Project Title: Water Lane, Angmering

Project No/ Document Reference: A290-TN007

DRAINAGE – CONDITIONS DISCHARGE

Aquacell Core Soakaway
Base layer 90.2m² x 0.4m deep
2nd layer 57.4m² x 0.4m deep
Base Invert Level: 12.90
Incoming Pipe invert 13.30
Volume of storage based on infiltration rate of
4.857 x 10⁻⁵ m/s

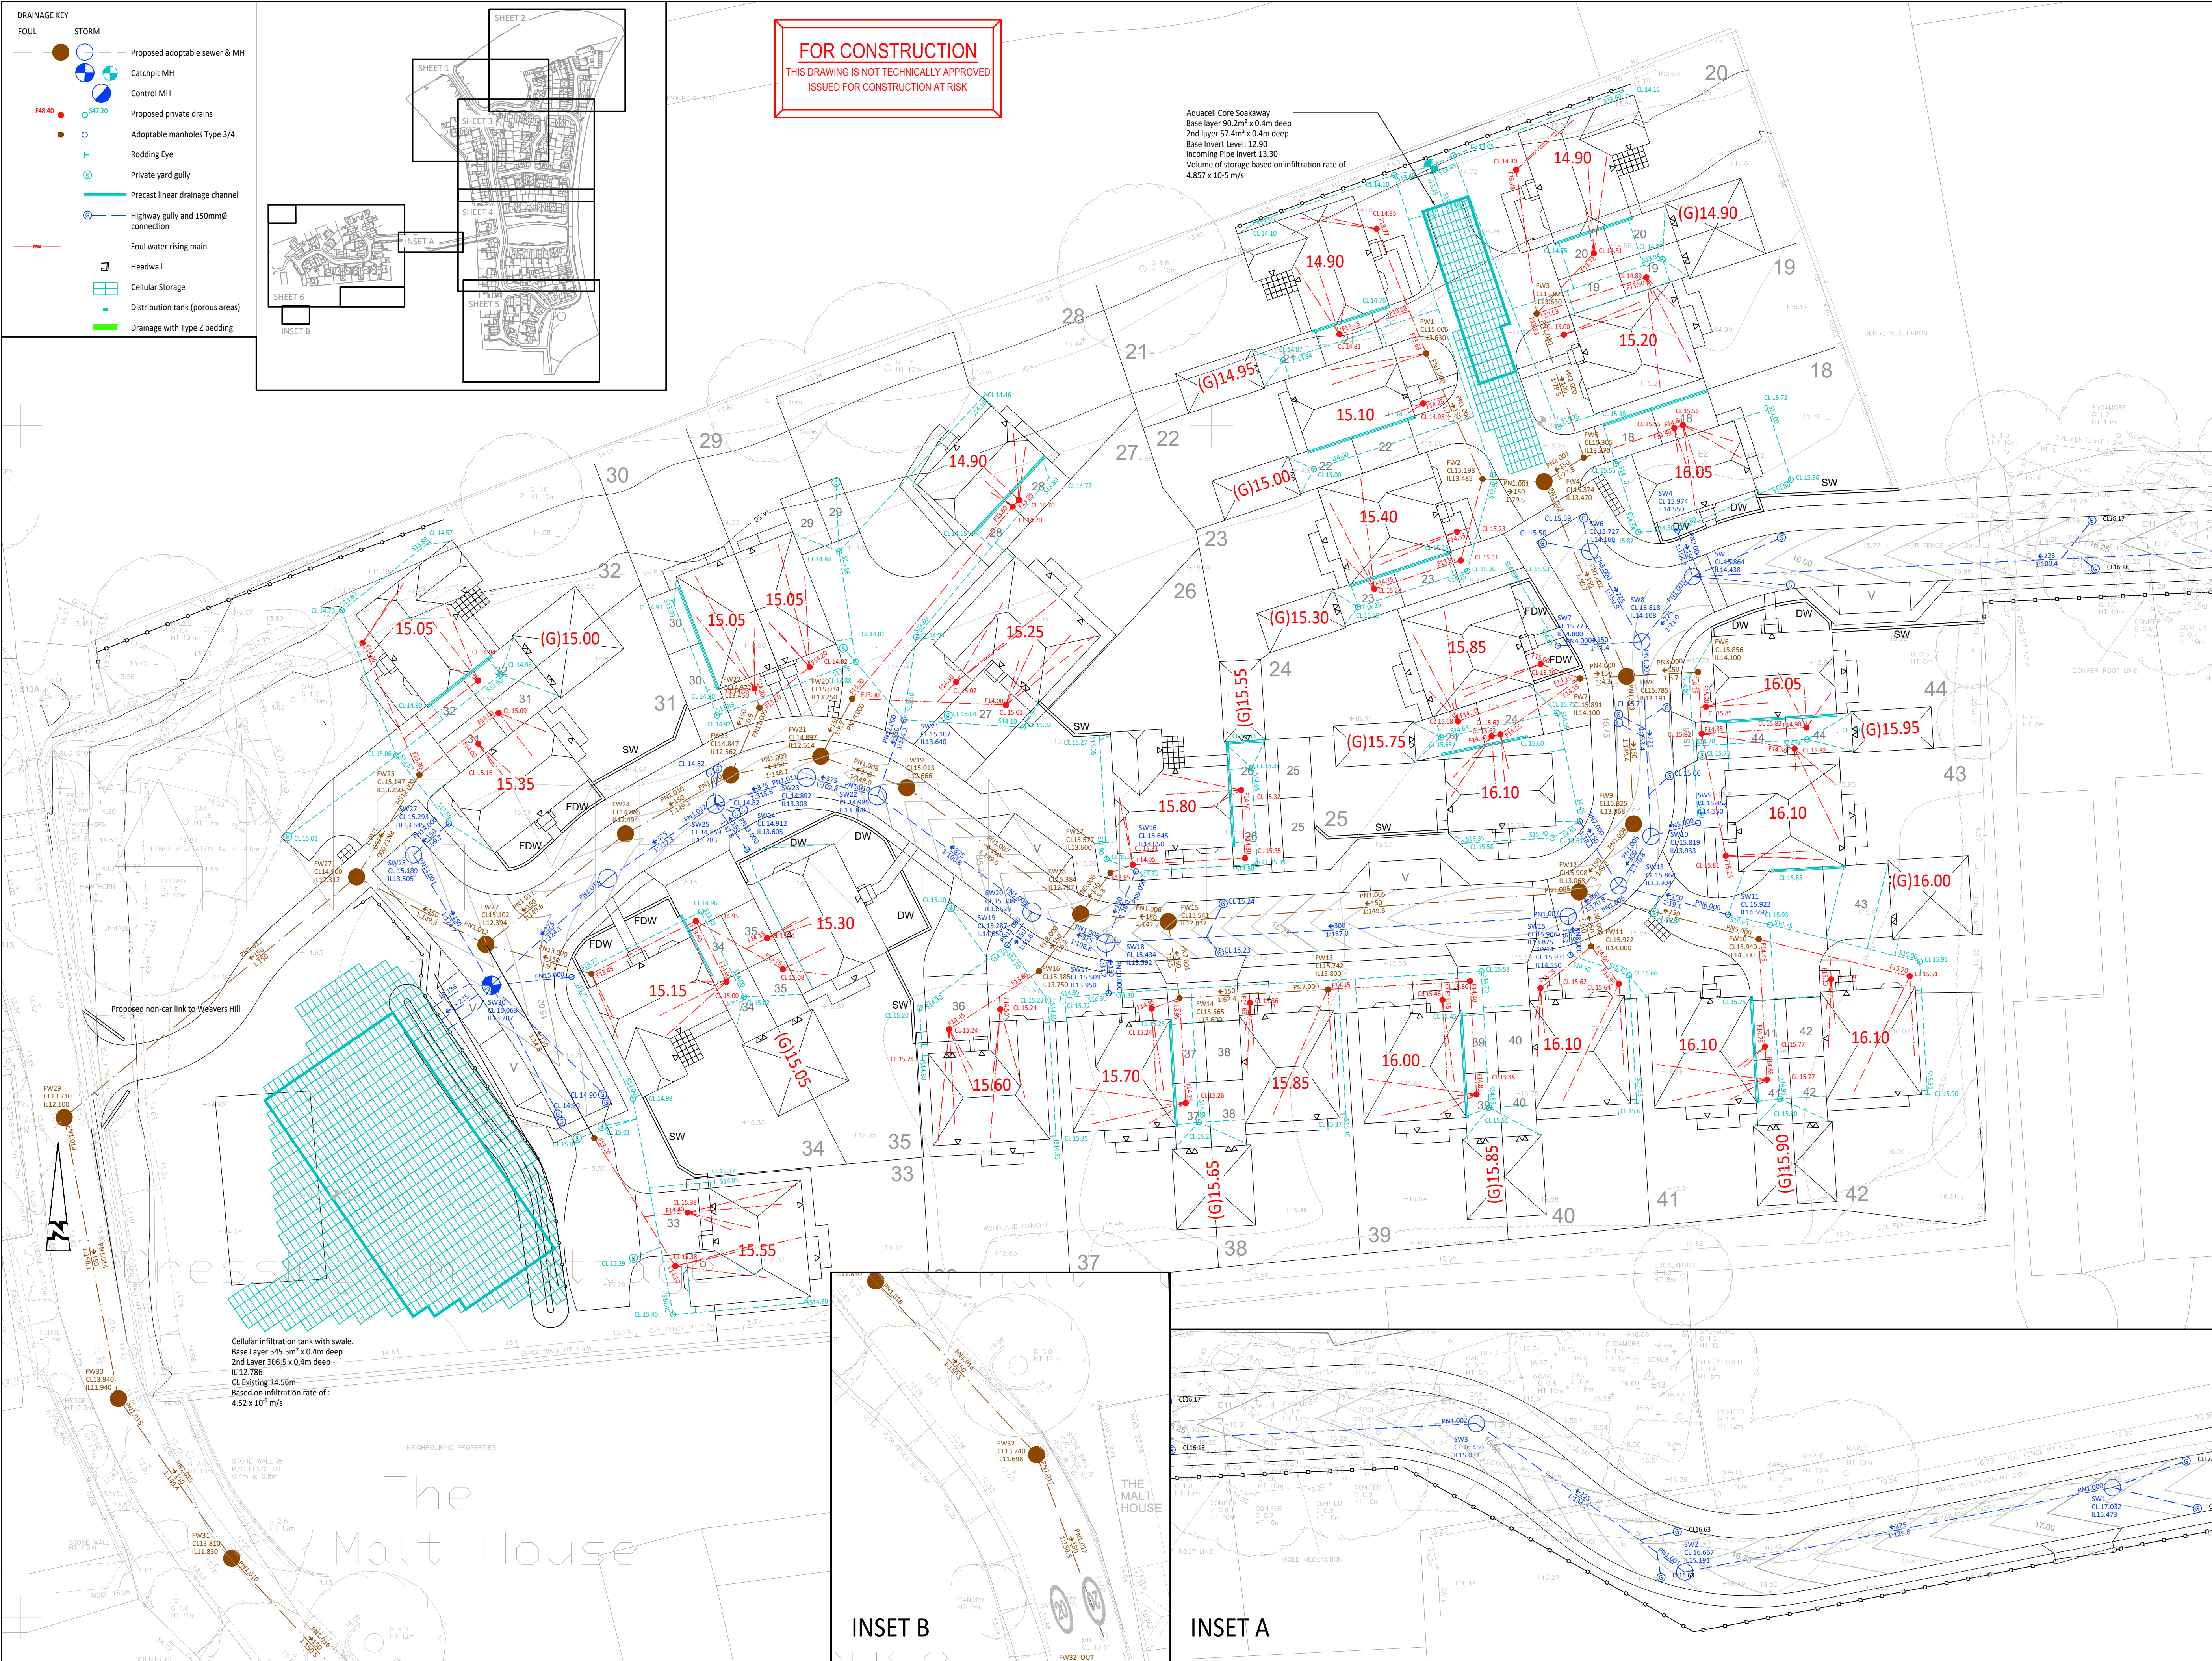
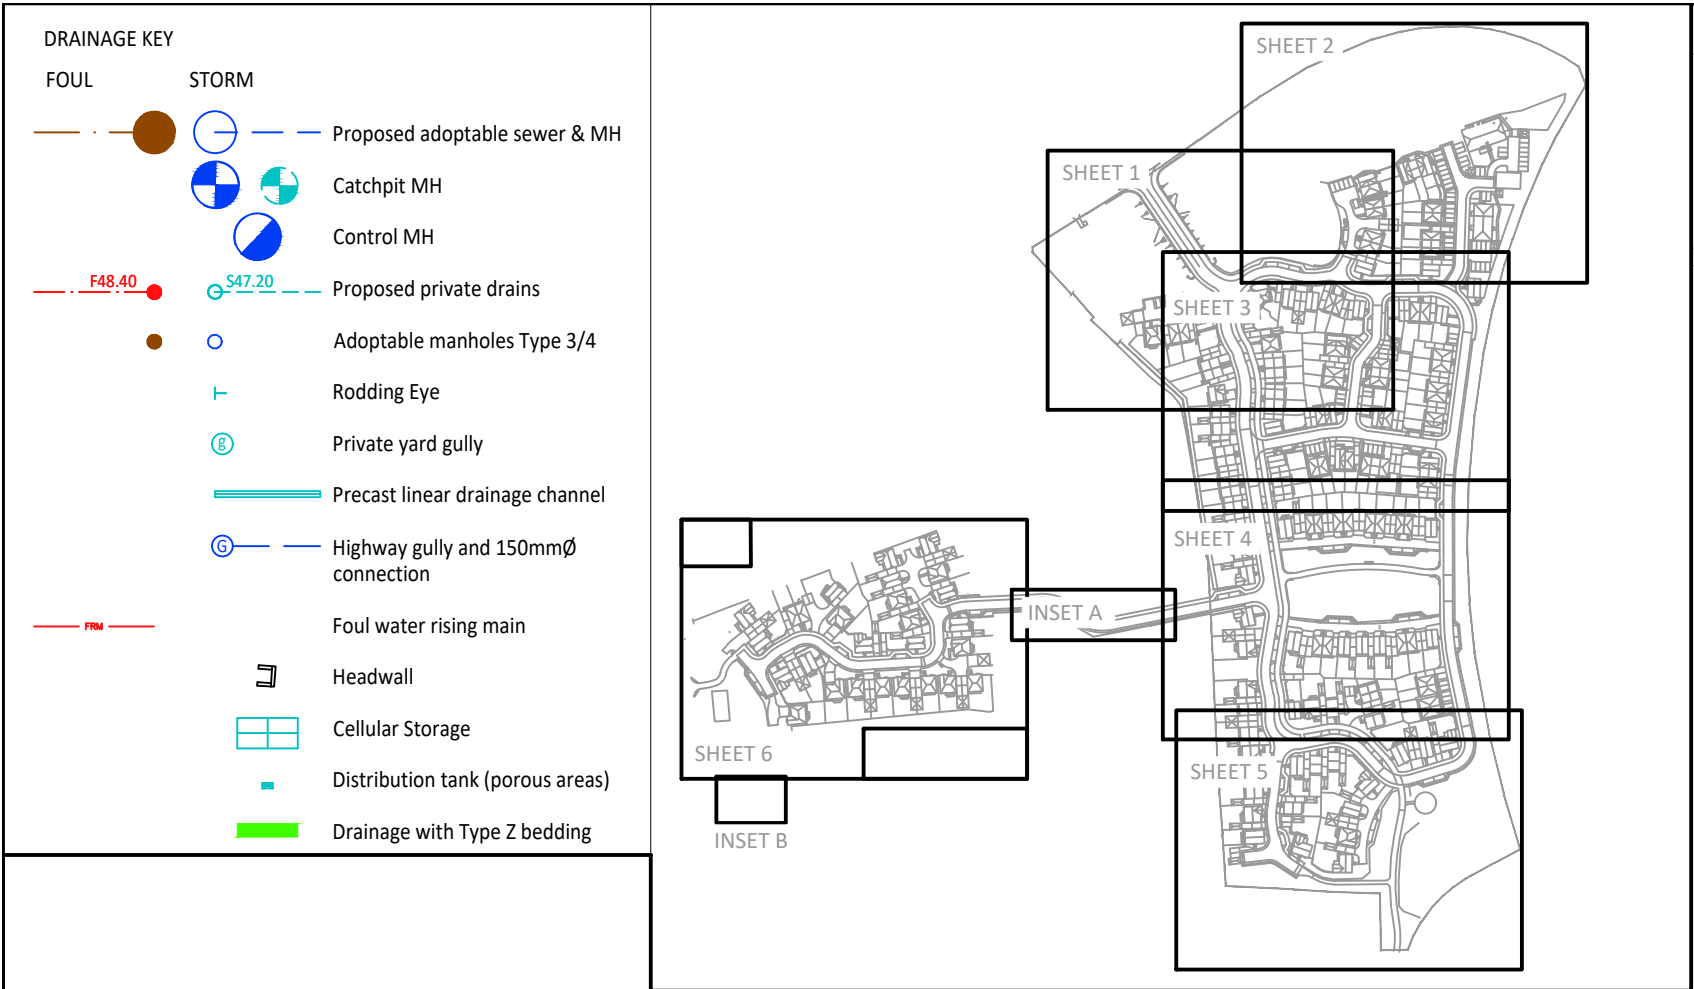
16. *The construction detail of the cellular soakaway needs to show the permeable liner around the crates, not around the sand to ensure the correct separation of material.*

17. *Invert level and depth of soakaway crates is inconsistent between surface water drainage layouts and construction detail drawings.*

18. *It appears that incoming pipe invert levels into the soakaway are at the base of the infiltrating structure. Incoming invert levels to infiltrating structures must be set above the 1 in 10 year plus cc event water level.*

This has been noted and included on the drawings.

This has been noted and included on the drawings.

As provided in our emails we state we apply to all design criteria wrt the 1:10 level and freeboard. However, you have queried this and also our calculations. To clarify we have provided two sets of calculations as requested and as per all other schemes and all previous submissions. The first set is the full design for all storms up to the 1:100 year plus climate change. This has been used to set all design criteria in accordance with industry standards including the 1:10 level and the freeboard. The design has then been tested to include Urban Creep in accordance with industry standard and ADC request. This is the second set of calculations. This proves the design still works if, in the future, further impermeable area is added, albeit there is minimal encroachment above the 1:10 level and in to the freeboard. We believe it is these calculations you are commenting on as to above the 1 in 10 and freeboard constraints.
